**STATE SIGNIFICANT DEVELOPMENT
ASSESSMENT REPORT:
4 Murray Rose Avenue, Sydney Olympic
Park
(SSD 6076)**

Secretary's Assessment Report
Section 89H of the
Environmental Planning and Assessment Act 1979

September 2014

Drawing Title  
**PADDOCK PARK**  
**FUTURE DETAIL PLAN**

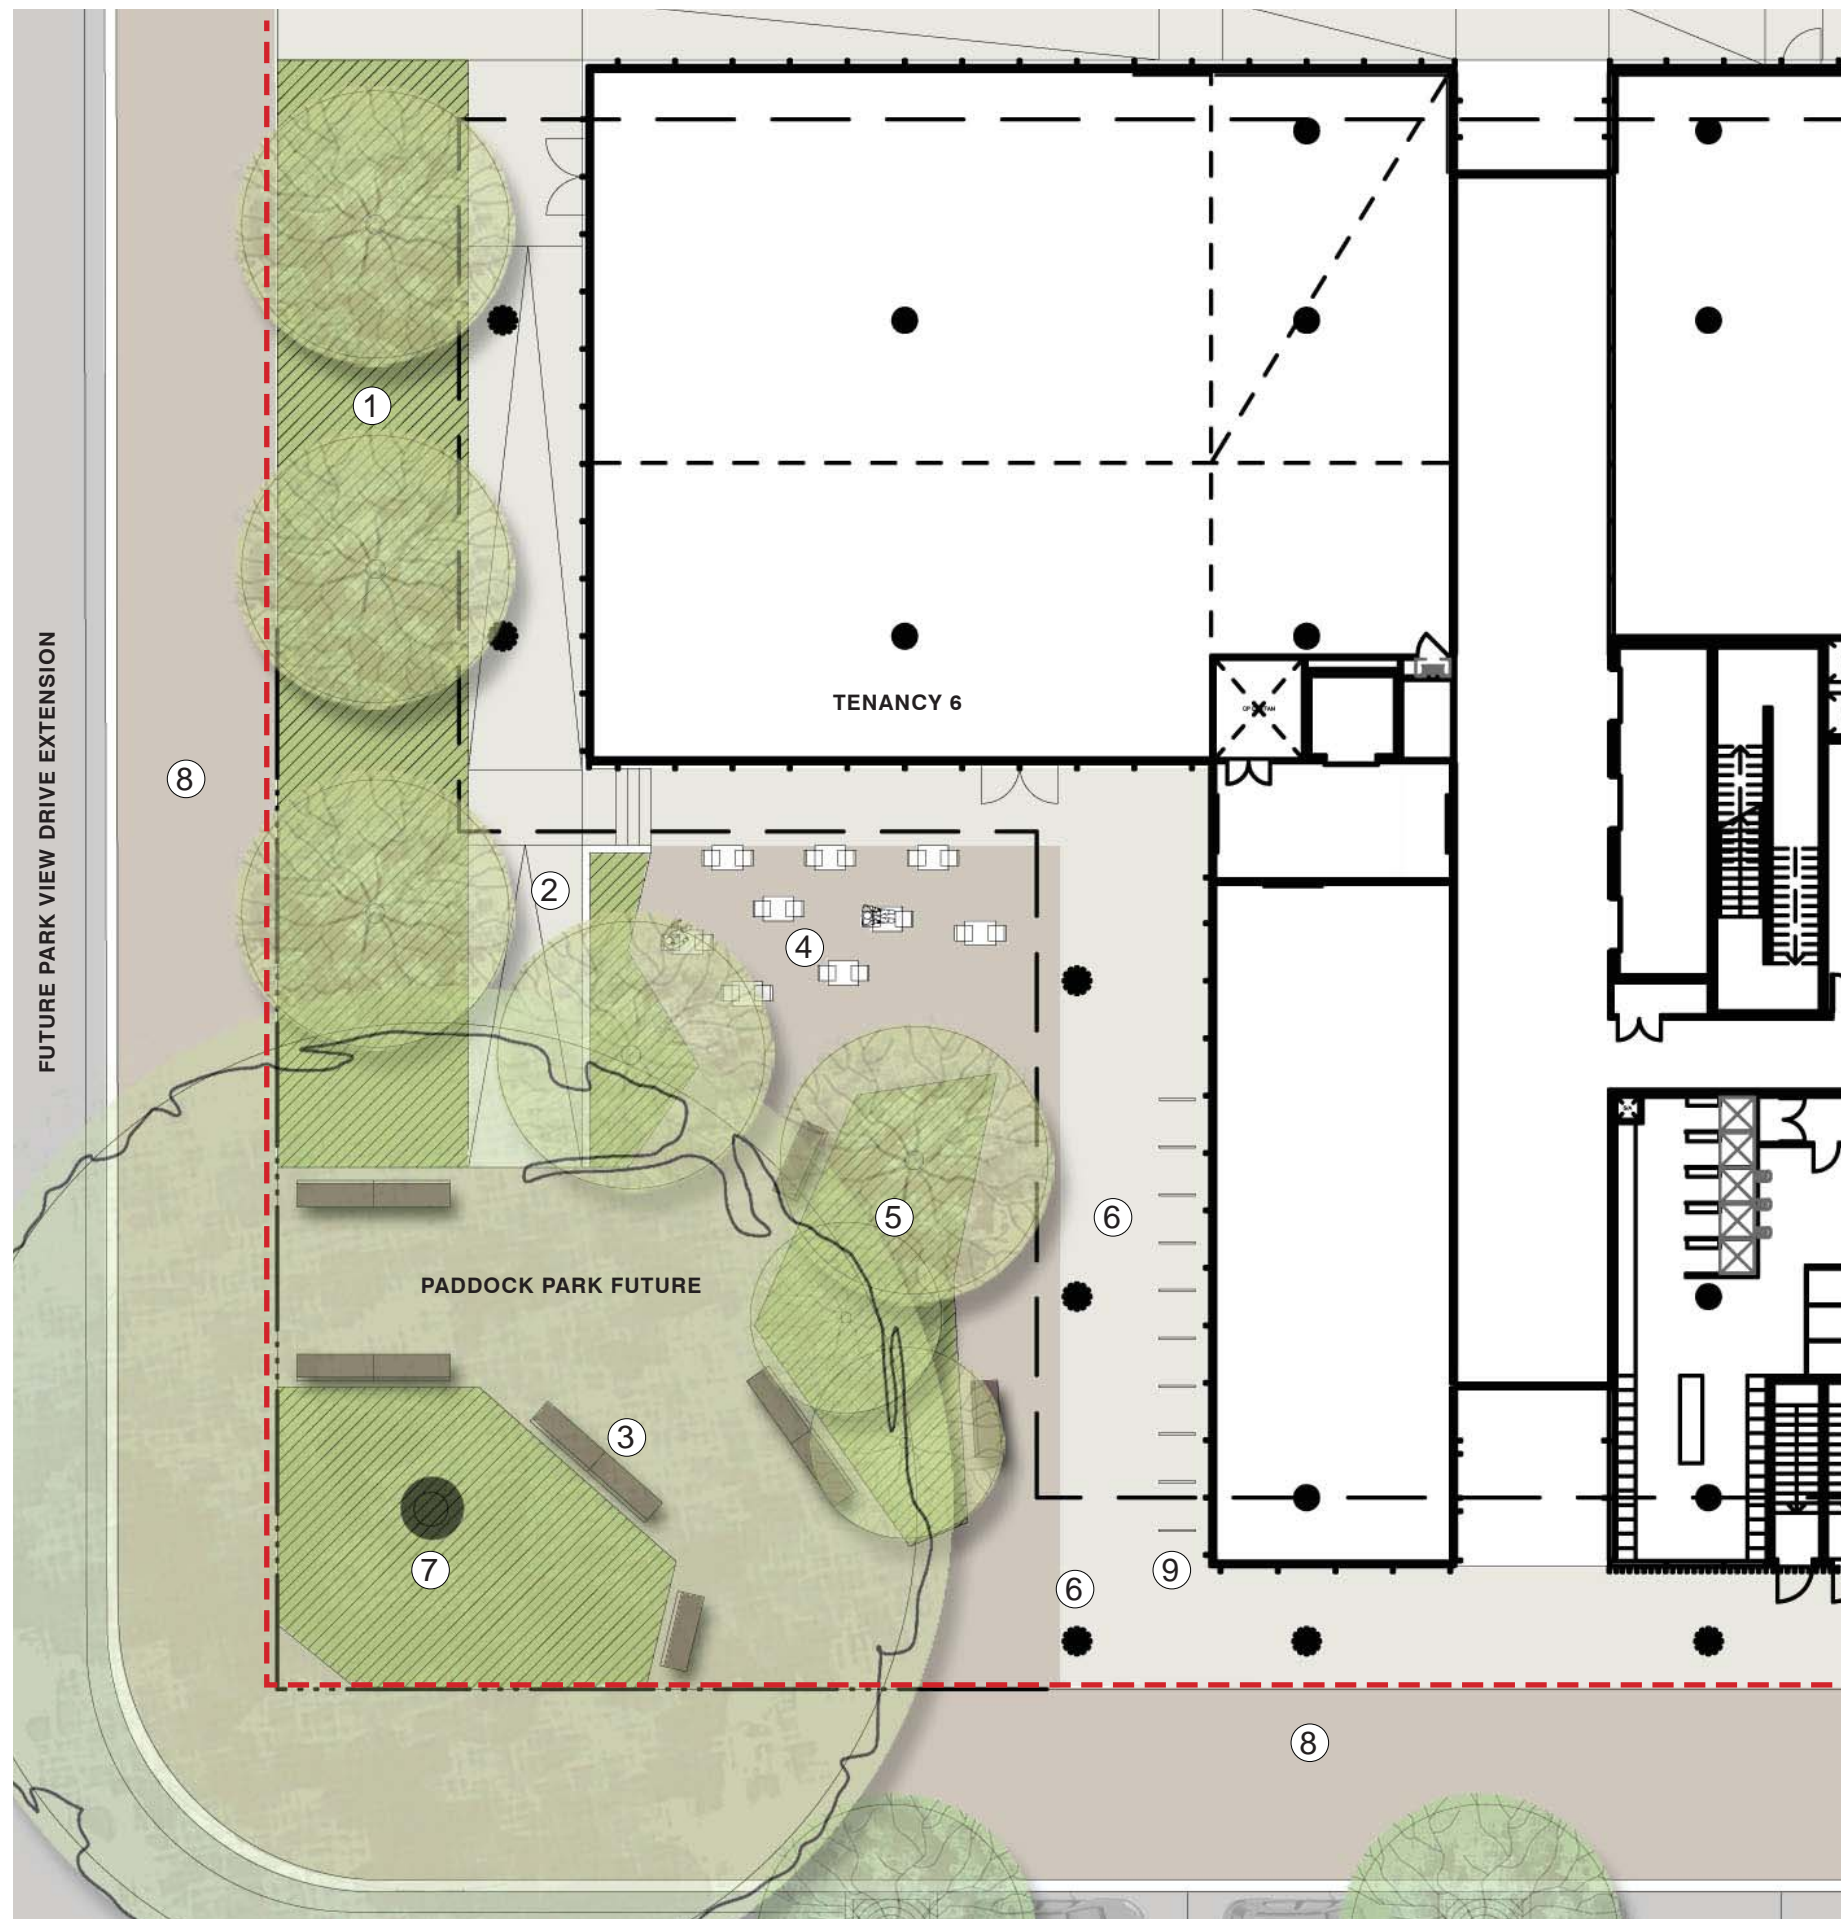
The originally submitted landscape design included exhaust flues associated with the basement car park ventilation system protruding in the public domain space in the south-western corner of the site. SOPA raised concern with the adverse amenity impact on future users of the public space to be known as 'Paddock Park'. The applicant provided amended plans with the RtS which show the exhaust system now integrated into the building fabric.

SOPA also raised concern with the connection between the future internal uses at ground level and the adjoining public domain space. The applicant amended the landscape design by deleting the ramps at the perimeter of Paddock Park, providing more at-grade hard paved area and the opportunity for outdoor seating to allow a better connection to the adjoining use. The adjoining internal area also includes additional door openings to allow for direct access to the open space. SOPA has advised the Department that the issues raised have been adequately resolved in the applicant's RtS. The Department considers that the building provides a strong connection with the landscape setting, and promotes visual and pedestrian connections through the site. The amendments to the landscape design and public domain spaces are shown in **Figure 6** at page 8 of this report.

- a dedicated pedestrian zone has been provided along the eastern boundary of the site;
- the landscape arrangement in Paddock Park has been modified by deleting the ramps and providing hard paving;
- the ground floor tenancy adjacent to Paddock Park includes additional door openings; and
- the roof top plant room has been re-configured.
